Application no: H16-0523-10

Description: Details of window frames, external doors and external materials (Conditions 2, 3, 7 and 8 of H16-0831-08)

Location: Elm Tree Farm
Mill Drove
Weston Hills
Spalding Lincs

Amendment: Amendment to window and door details
(dwg. no. 2126-10.01C)

DOOR & WINDOW DETAILS

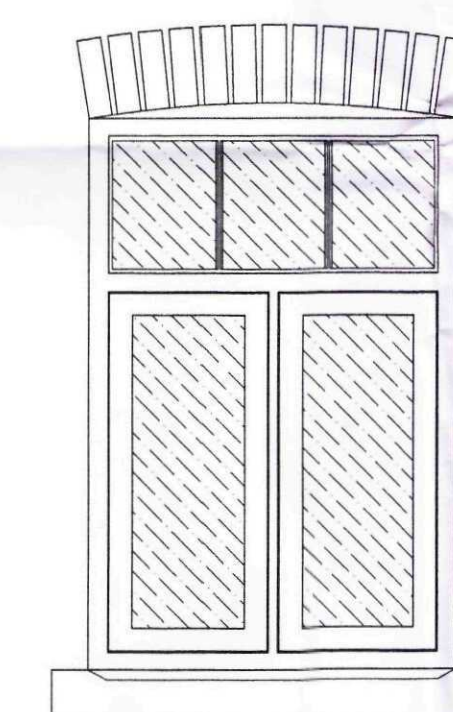
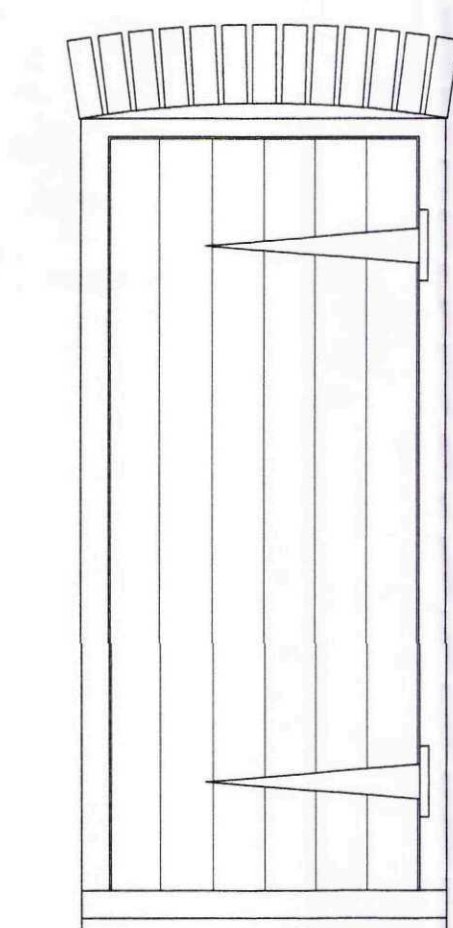
This is fine- only comment I'd make is that it's bead and butt not bead and buff boarding...

Also, I need the details of the slate (manufacturer etc), which should cover durability and colour stability. Once we have that I'll be able to pass this through for approval.

Spelling mistake corrected.
